From: Laura Gibbons
Sent: 24 June 2019 09:39
To: Planning.Responses <Planning.Responses@arun.gov.uk>
Cc: Juan Baeza <Juan.Baeza@arun.gov.uk>
Subject: RE: Planning Consultation on: F/11/19/PL

Engineers Comments Regarding Surface Water Drainage

APPLICATION F/11/19/PL

Description of Works: Construction of agricultural barn with flexible storage use (B8 Use Class) with ancillary office space

Modelled Flood Outlines (Undefended Tidal) Map. Centred BN18 0DF. Created 9/4/18.

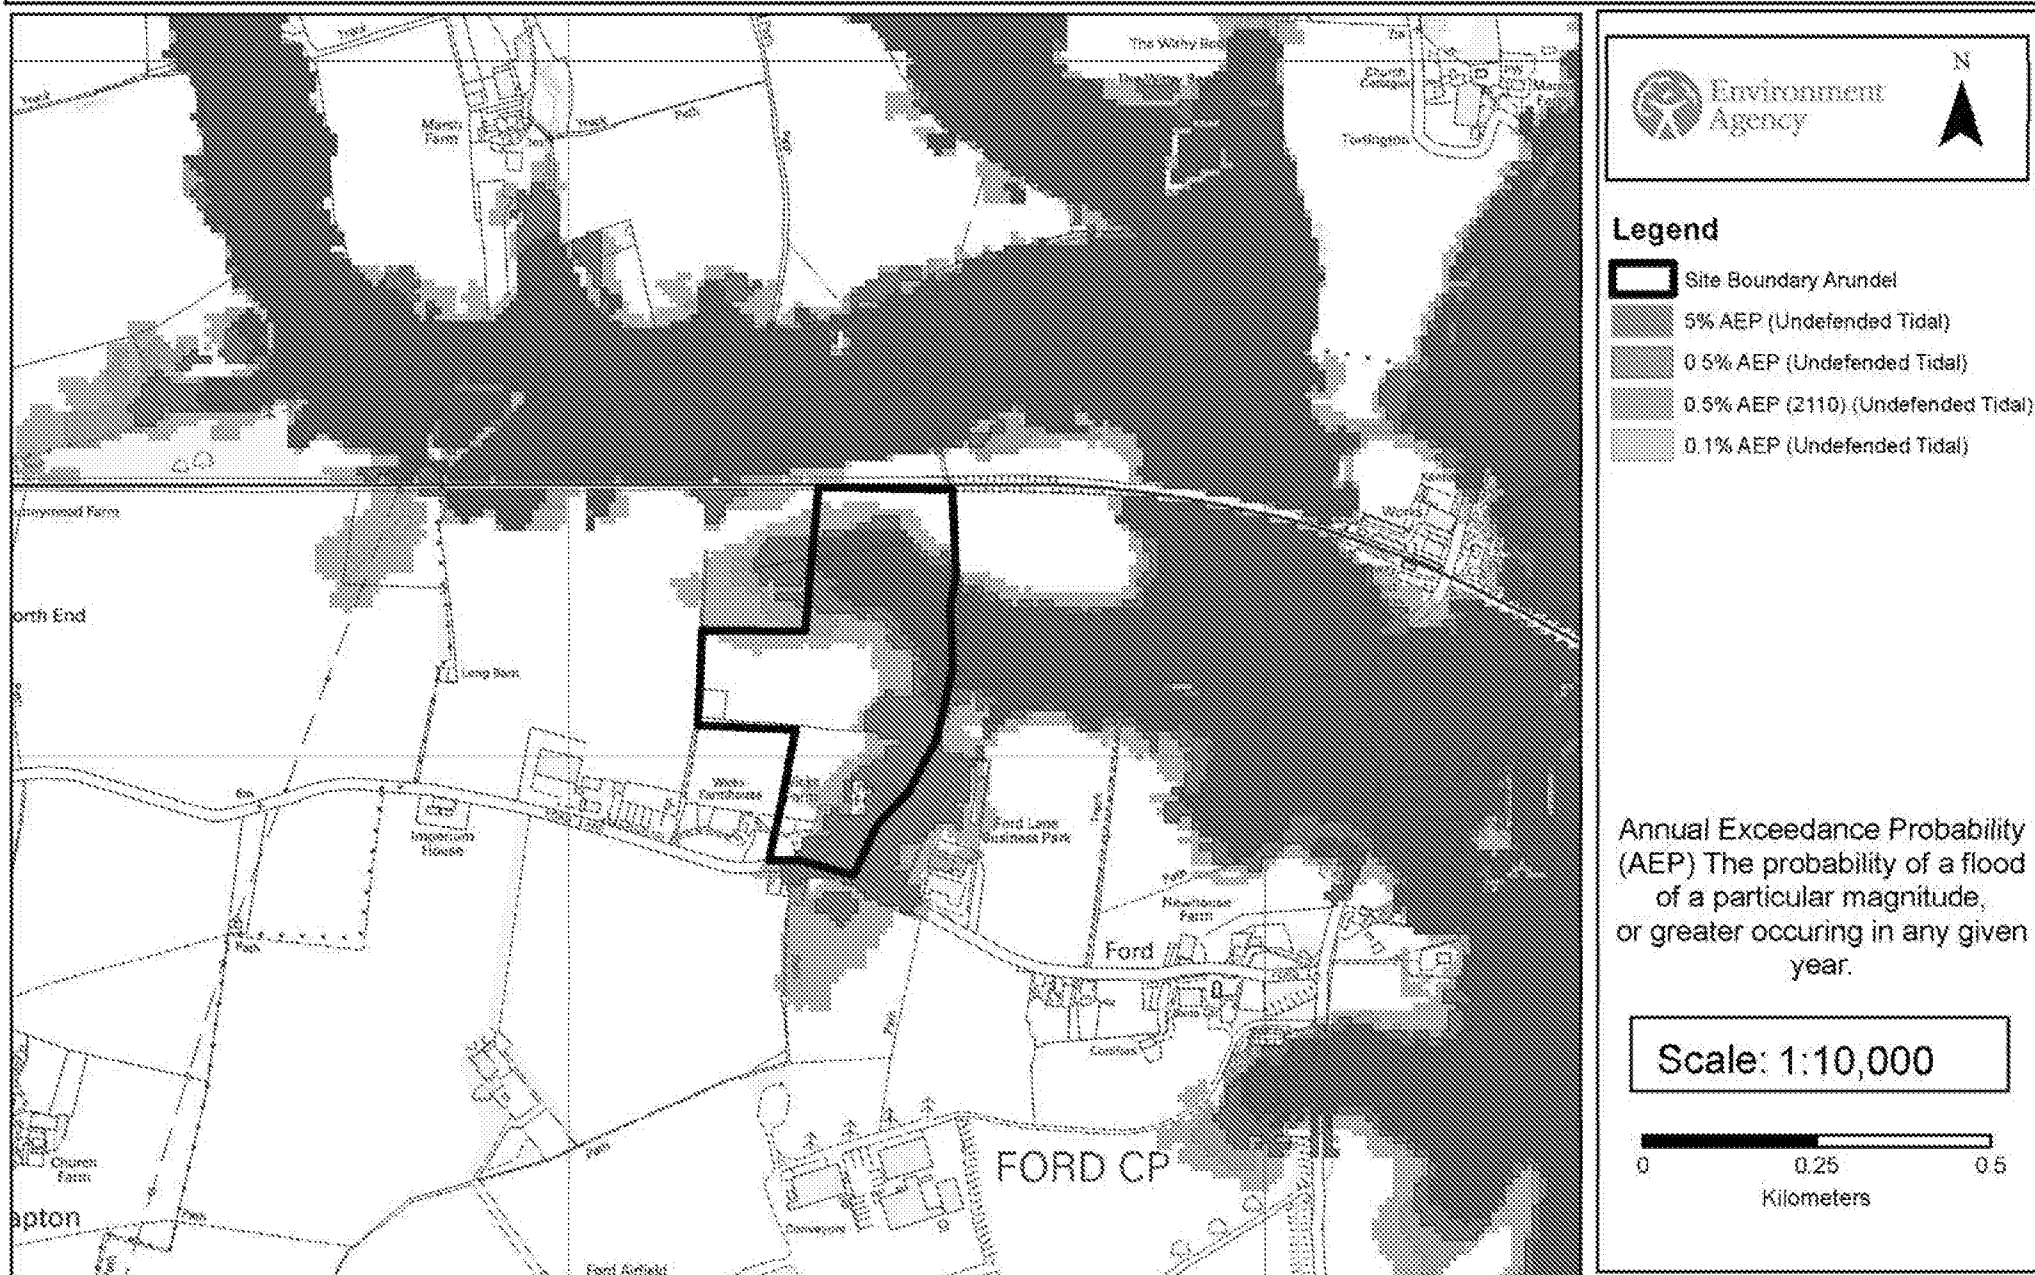
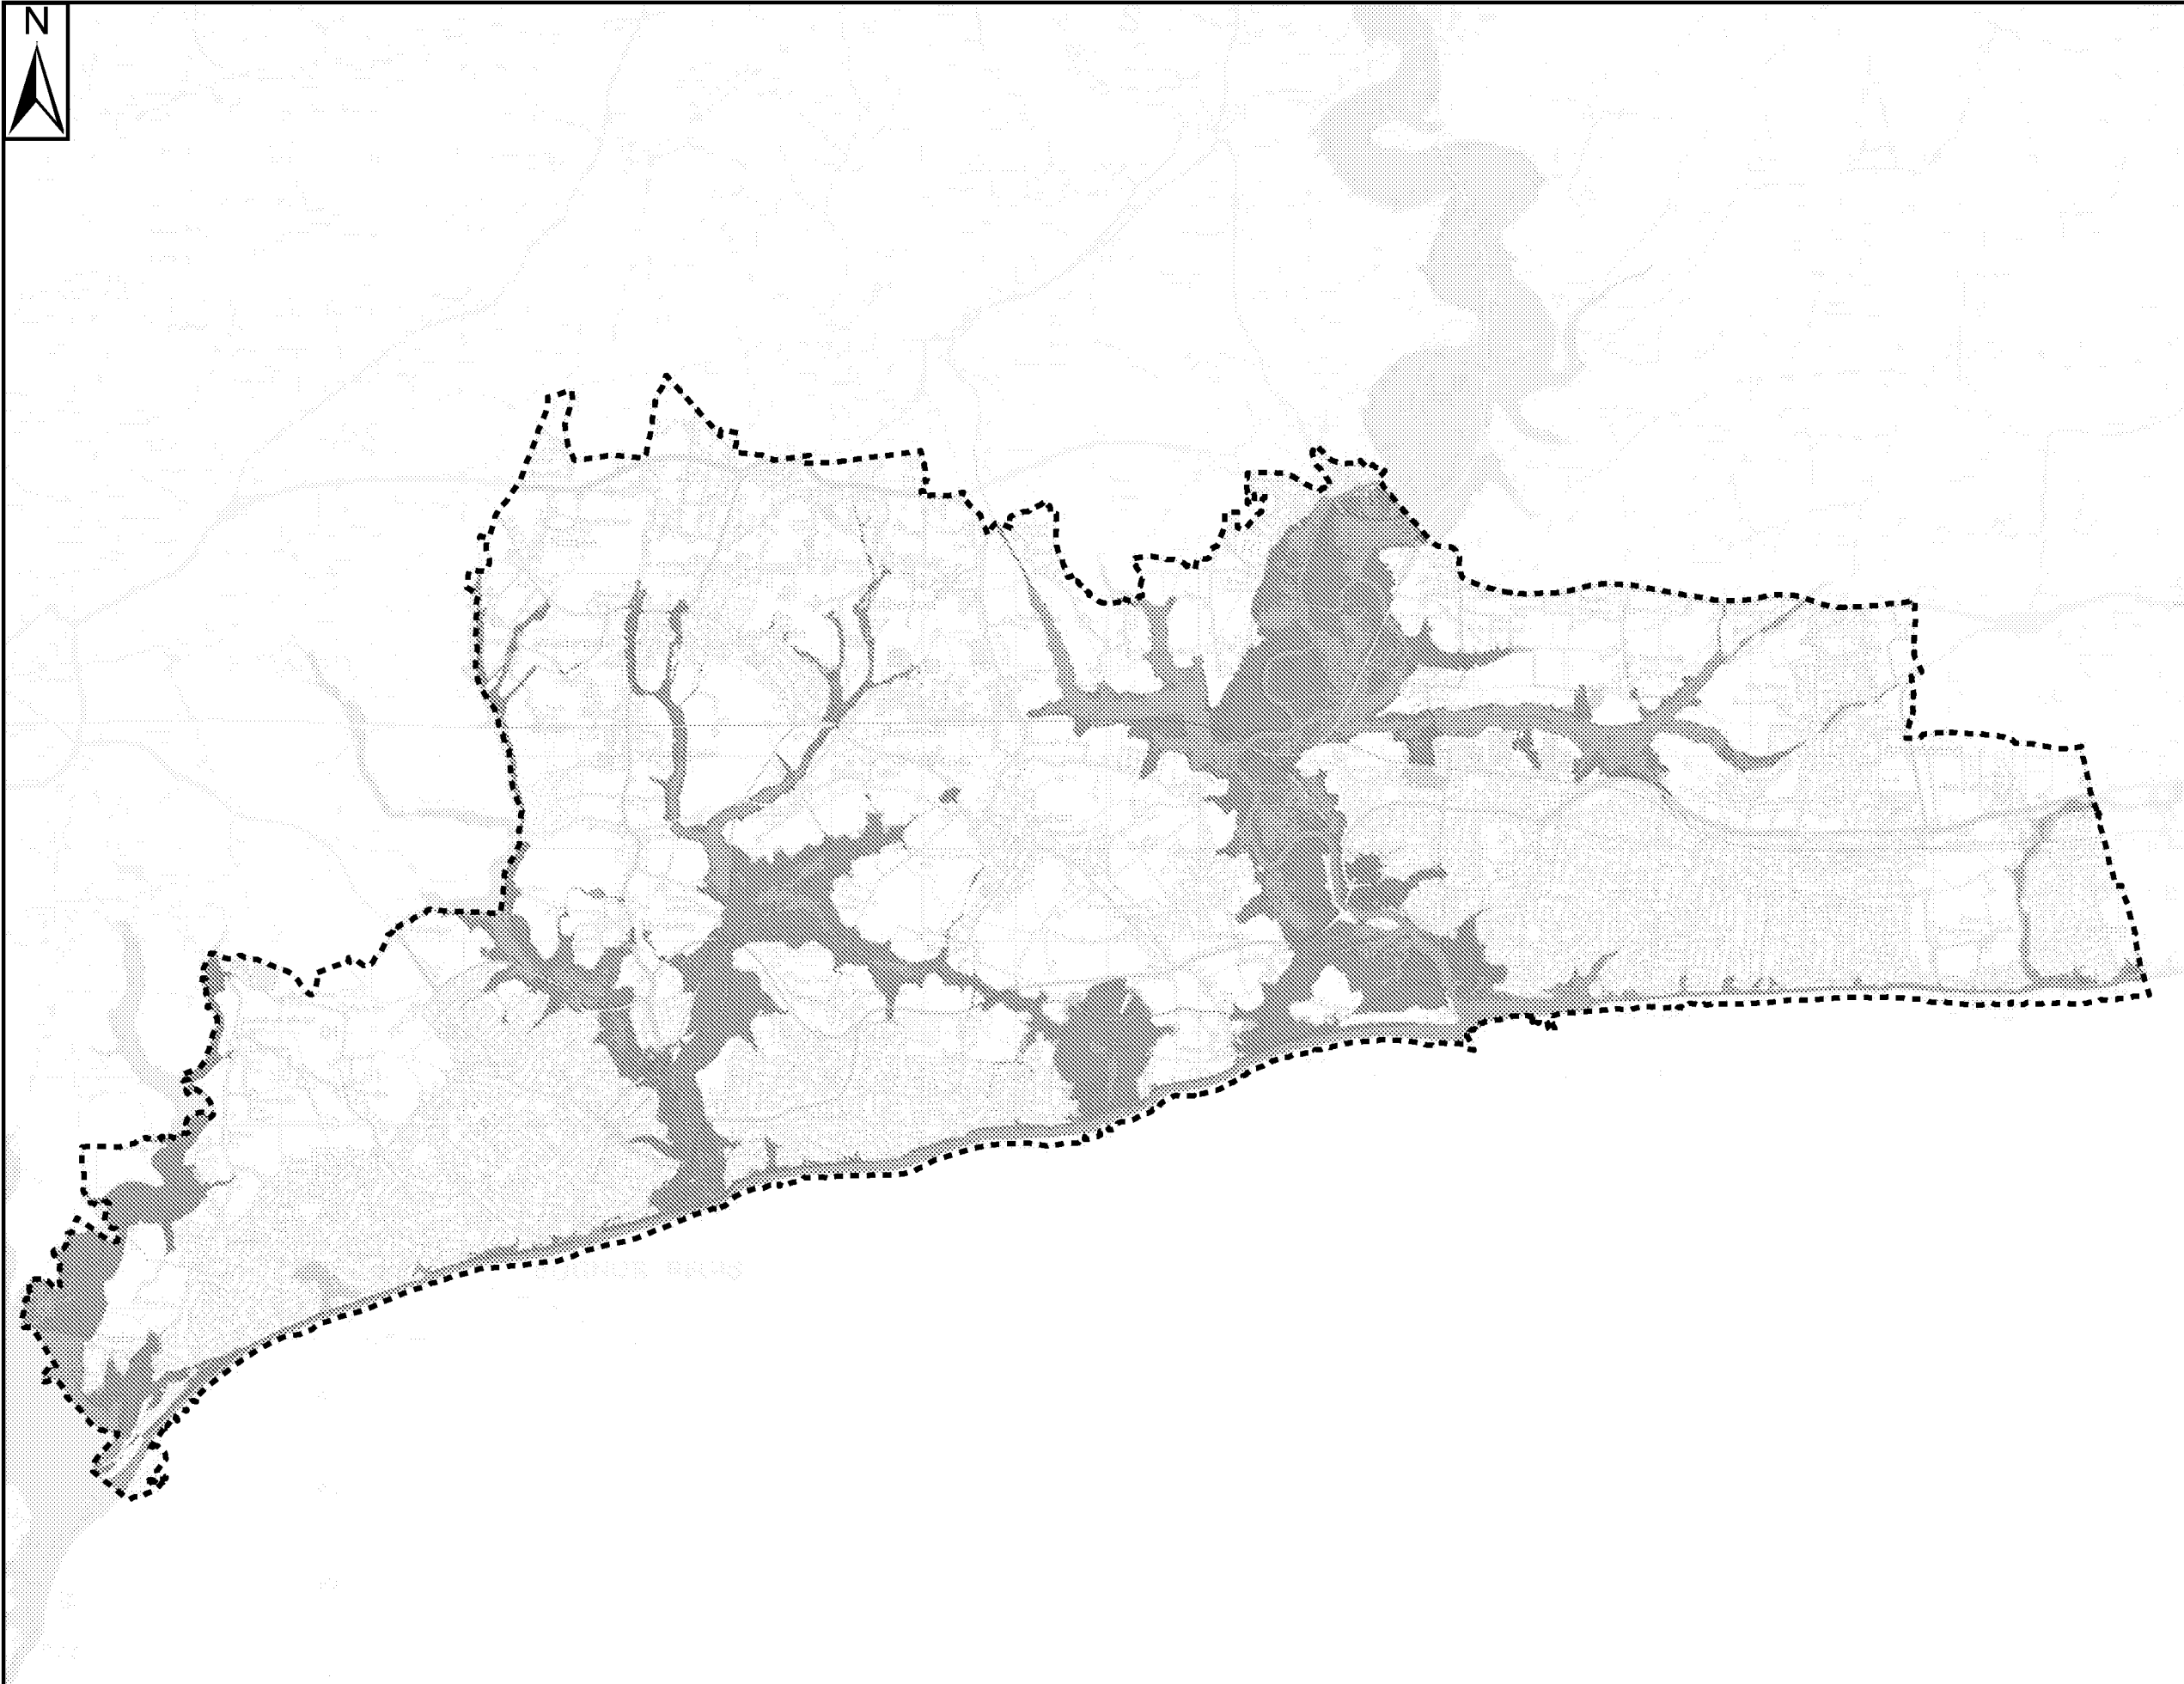
The application has areas within flood zone 1, 2 and 3. The Environment Agency should therefore be consulted. Surface water drainage features should not be located within flood zone 3.
